NORFOLK BOREAS OFFSHORE WIND FARM

Planning Inspectorate Reference: EN010087

Natural England's response to
DCO documents submitted at Deadline 5 and 6

31st March 2020

Royal HaskoningDHV
Enhancing Society Together

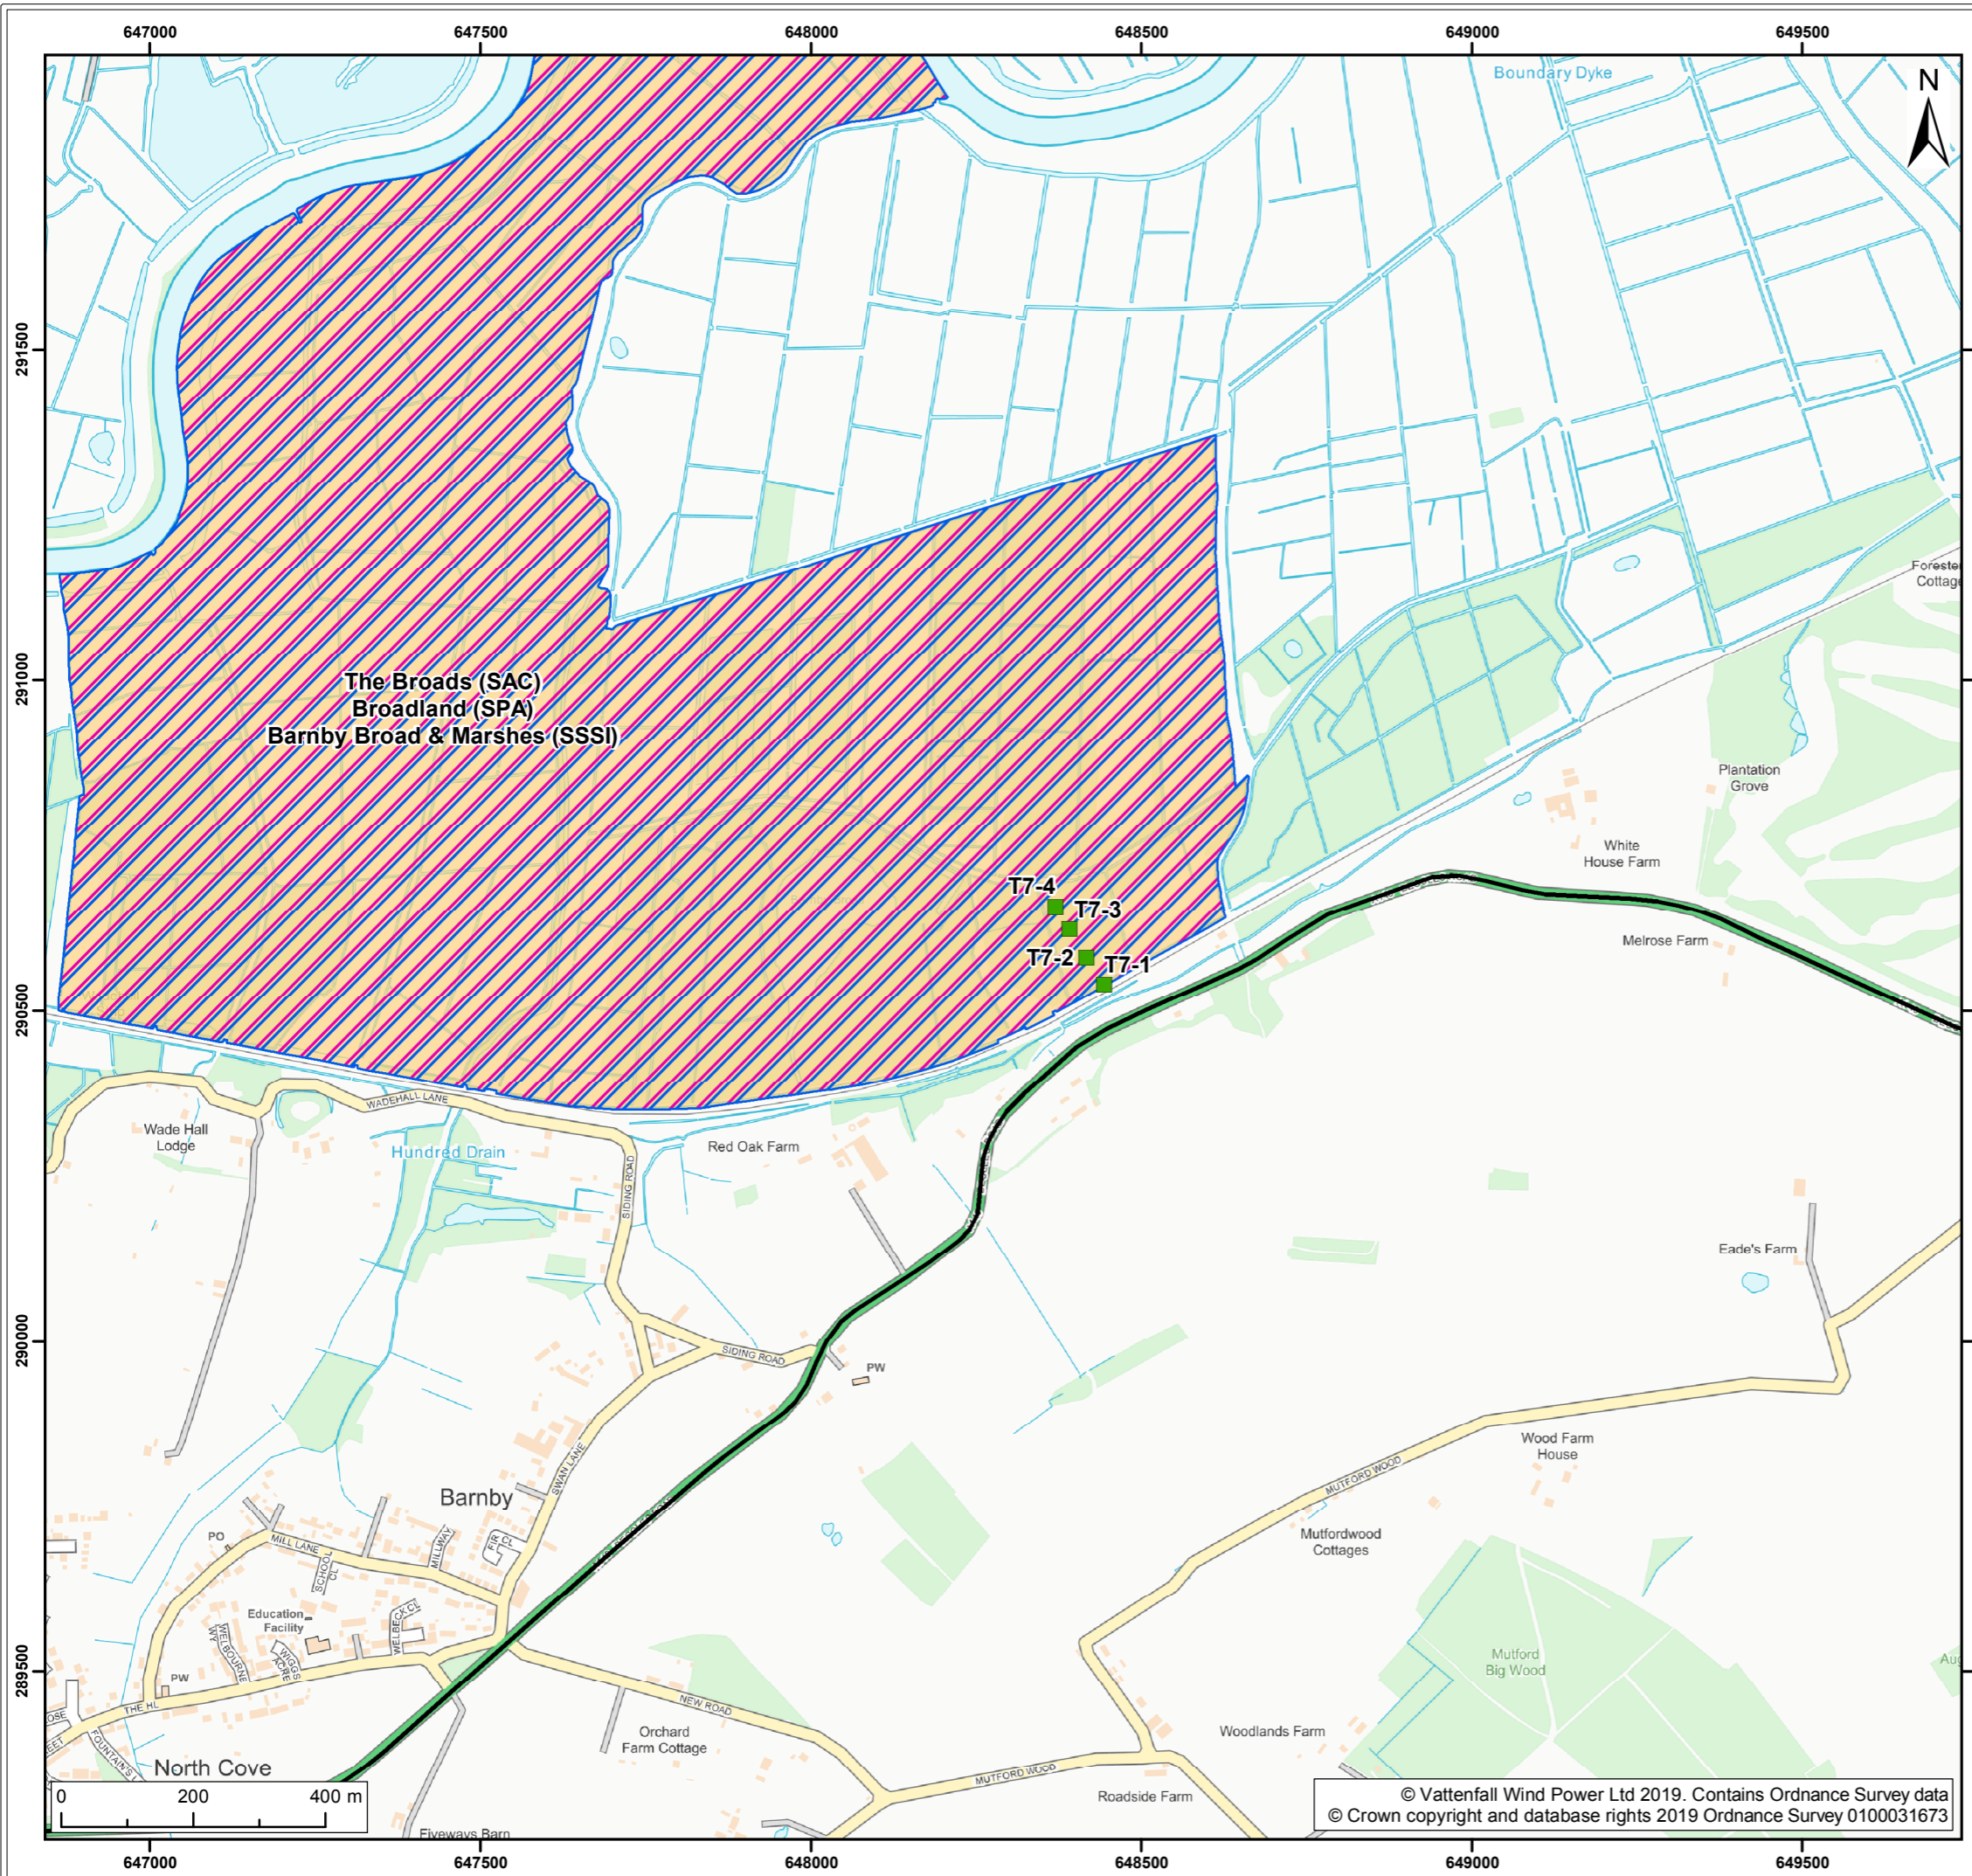
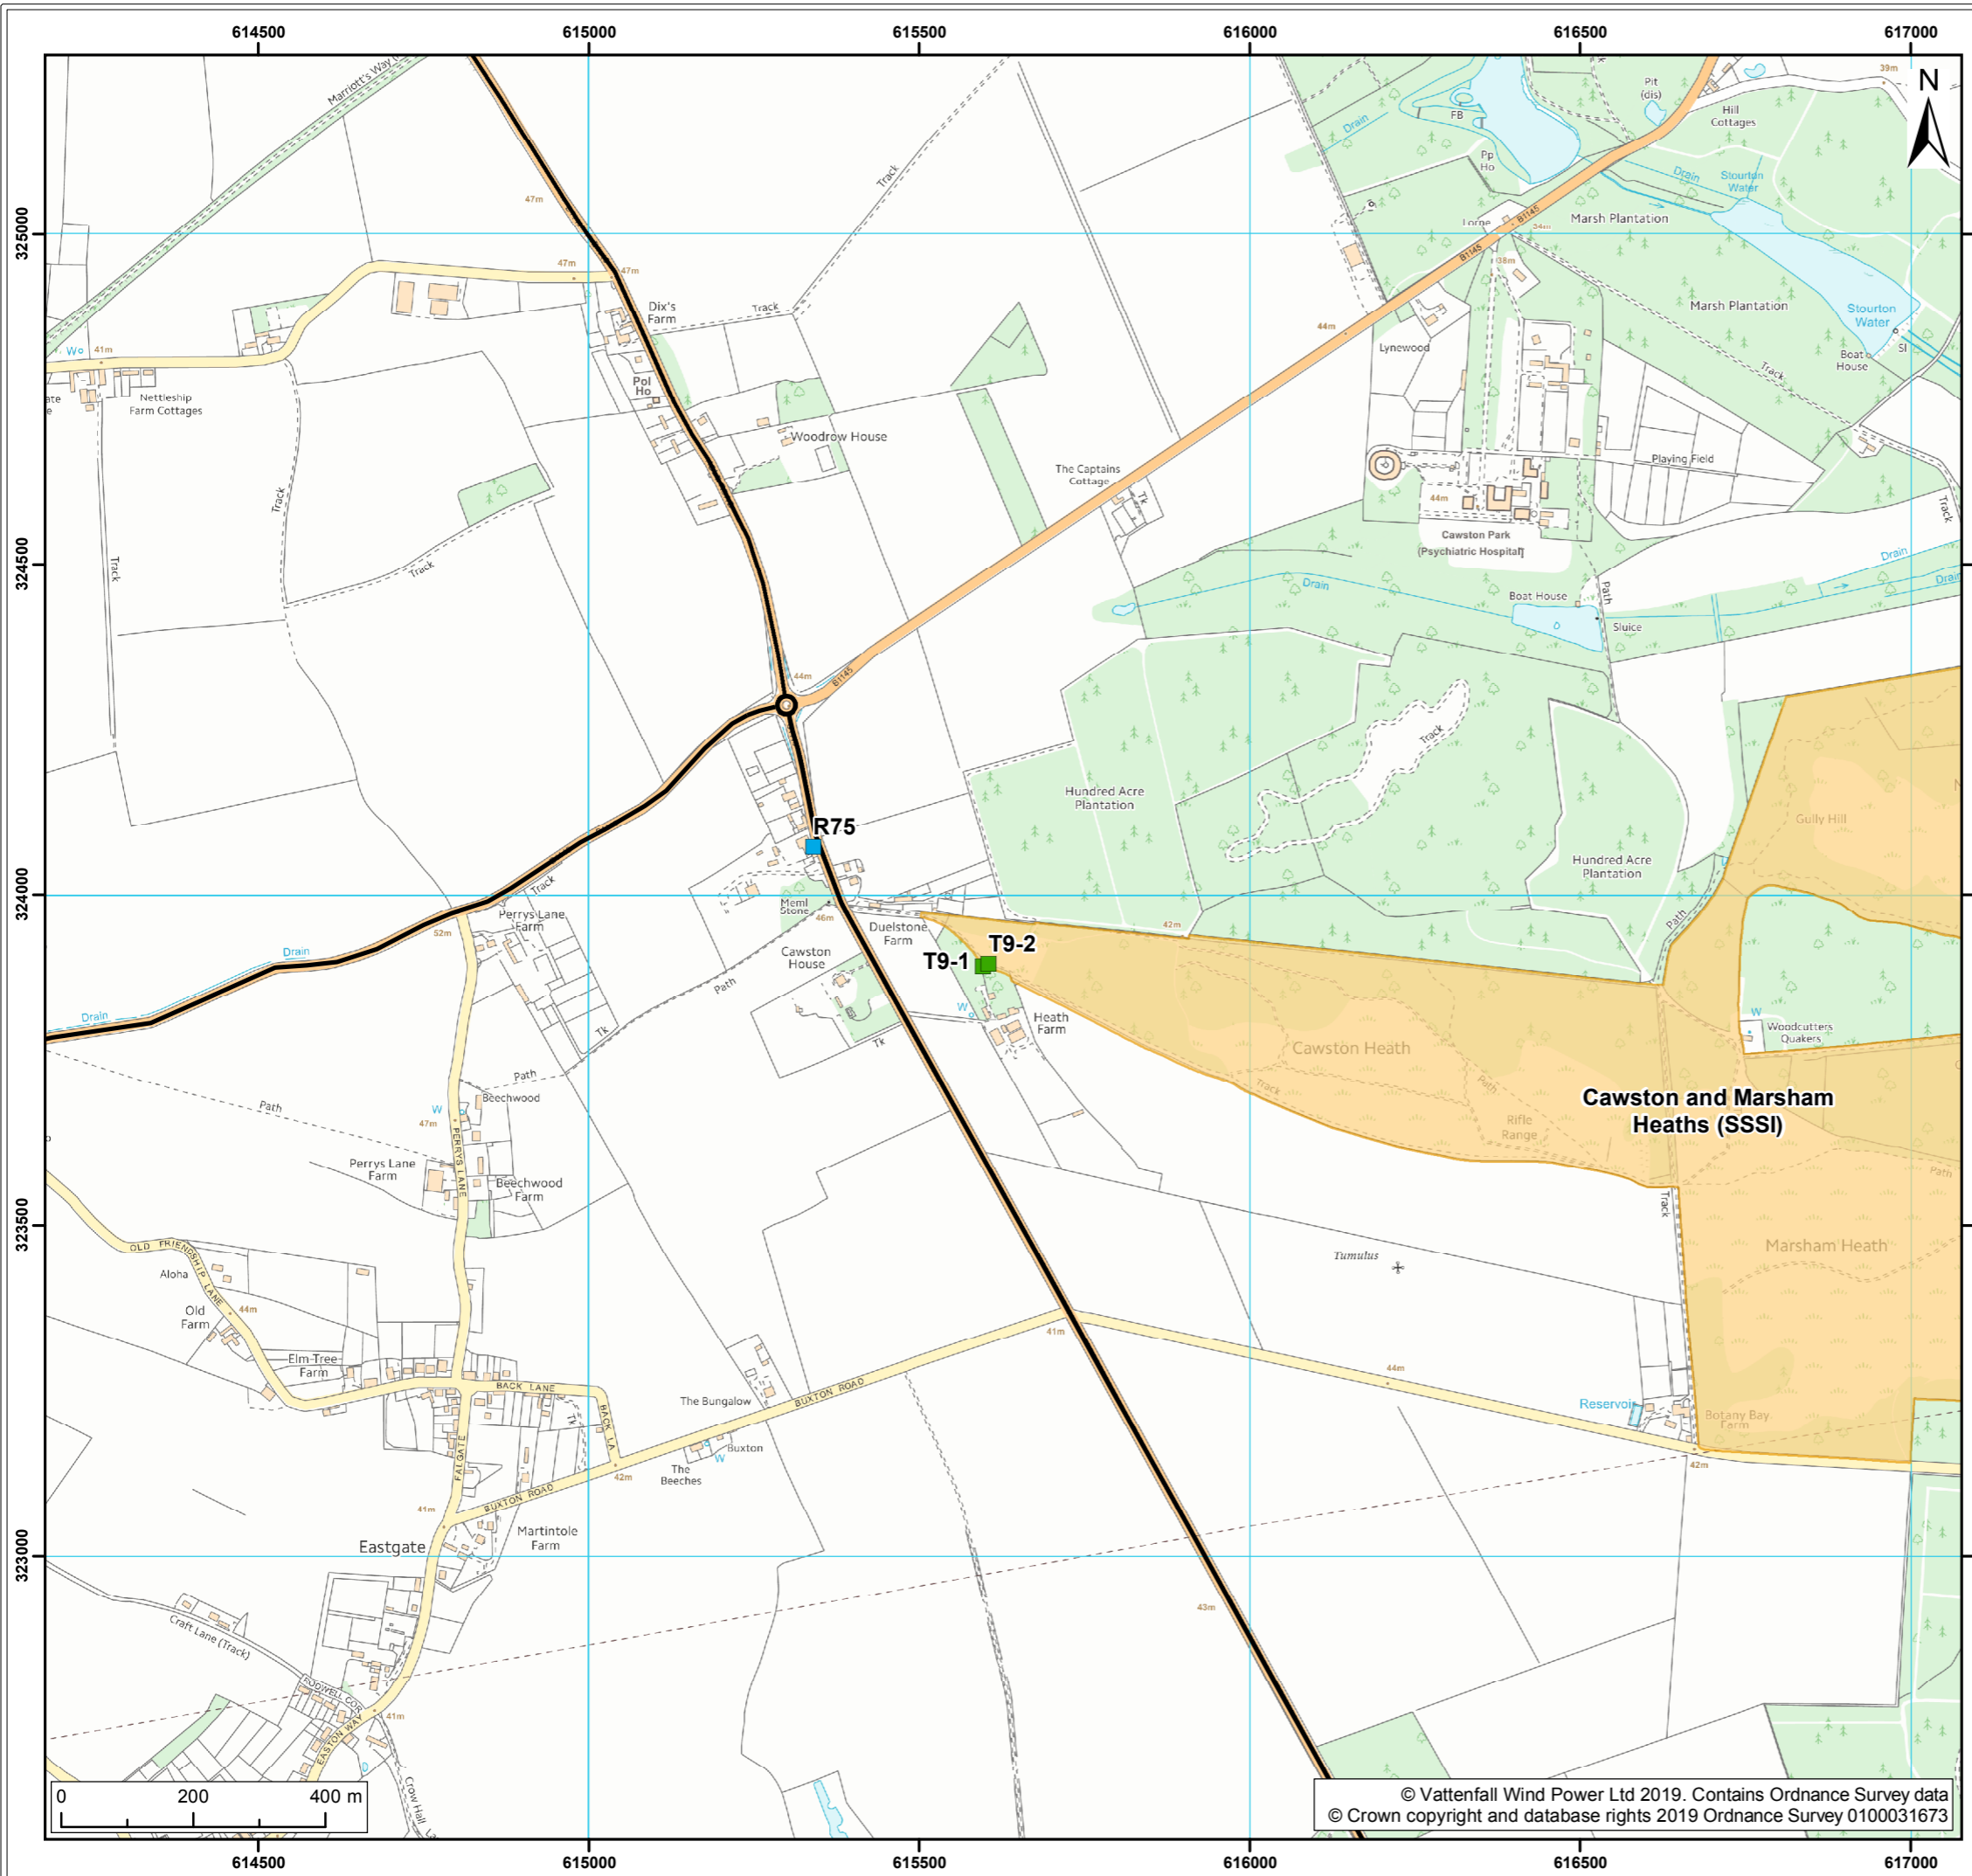
8.8 Outline Traffic Management Plan Version 3		
74	17	Welcome inclusion of para 74 in OTMP, advise that the Applicant include ES figure 26.5 as an Appendix to the OTMP to allow reference should the ES not be publicly available by the time of construction.
		This does not show the location of designated sites sensitive to air quality in relation to the traffic and HGV routes, either alone or in combination with other developments. Advise that the Applicant include ES figure 26.5 as an Appendix to the OTMP.
